Permit No **990254**

Location of Construction: **Portland, ME 20 Sixth Street** Phone: **797-9717**

Proposed Project Description: **Build 11x12 2 story addition with interior renovations.**

DATE: 3/23/99 ADDRESS: 20 SIXTH ST. CBL: 340-E-1013 #14
 REASON FOR PERMIT: To build 2nd story addition 11x12'
 BUILDING OWNER: Gabor Korthy
 PERMIT APPLICANT: Regal Renovations & Design
 USE GROUP R-3 BOCA 1996 CONSTRUCTION TYPE 5B

Copy of The Original & Submitted PLAN

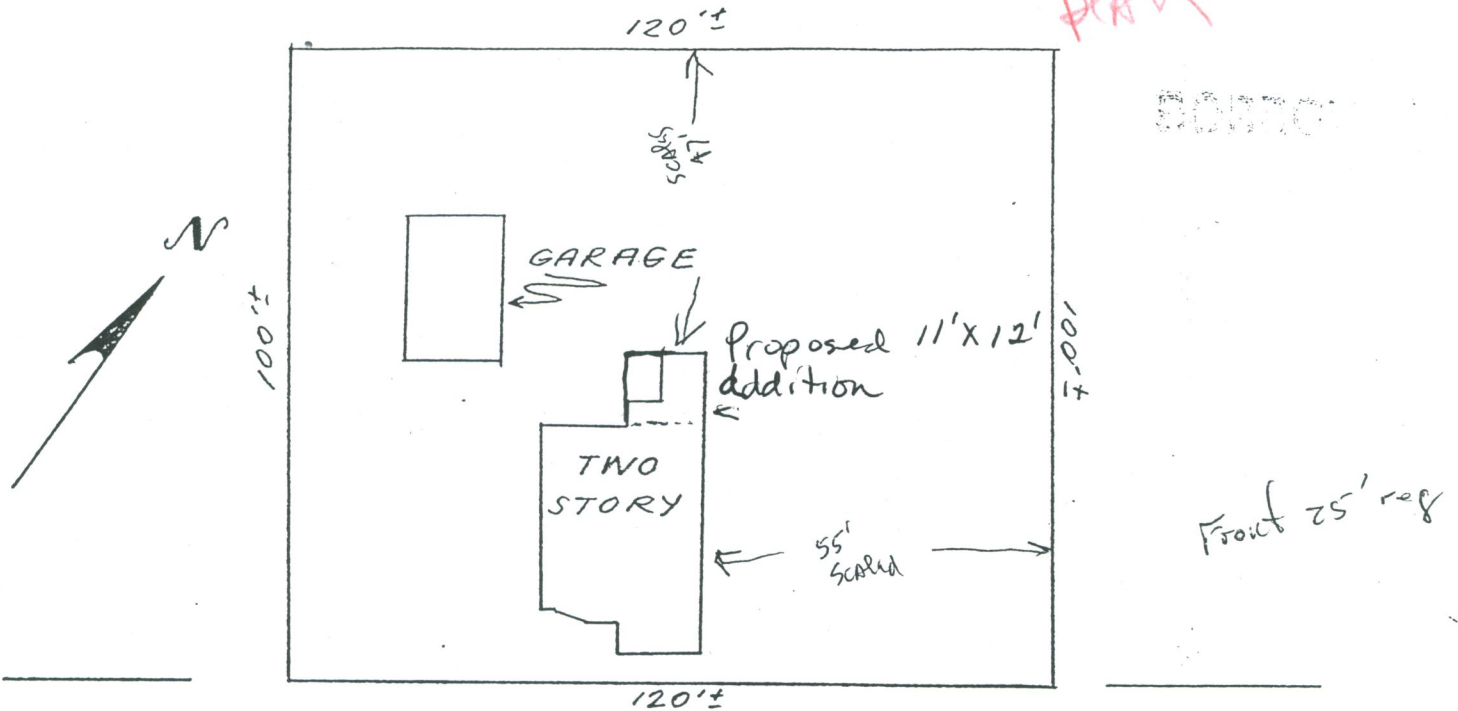
11. Other requirements of condition your submitted plot plan states "structure violates 15' setback Deed restriction". Although your submitted plan shows you meet City required setbacks, you still must meet any private setback deed restrictions. You shall be

required to submit new plans if there is any changes to your proposal. Marge Schmuckal, Zoning Administrator
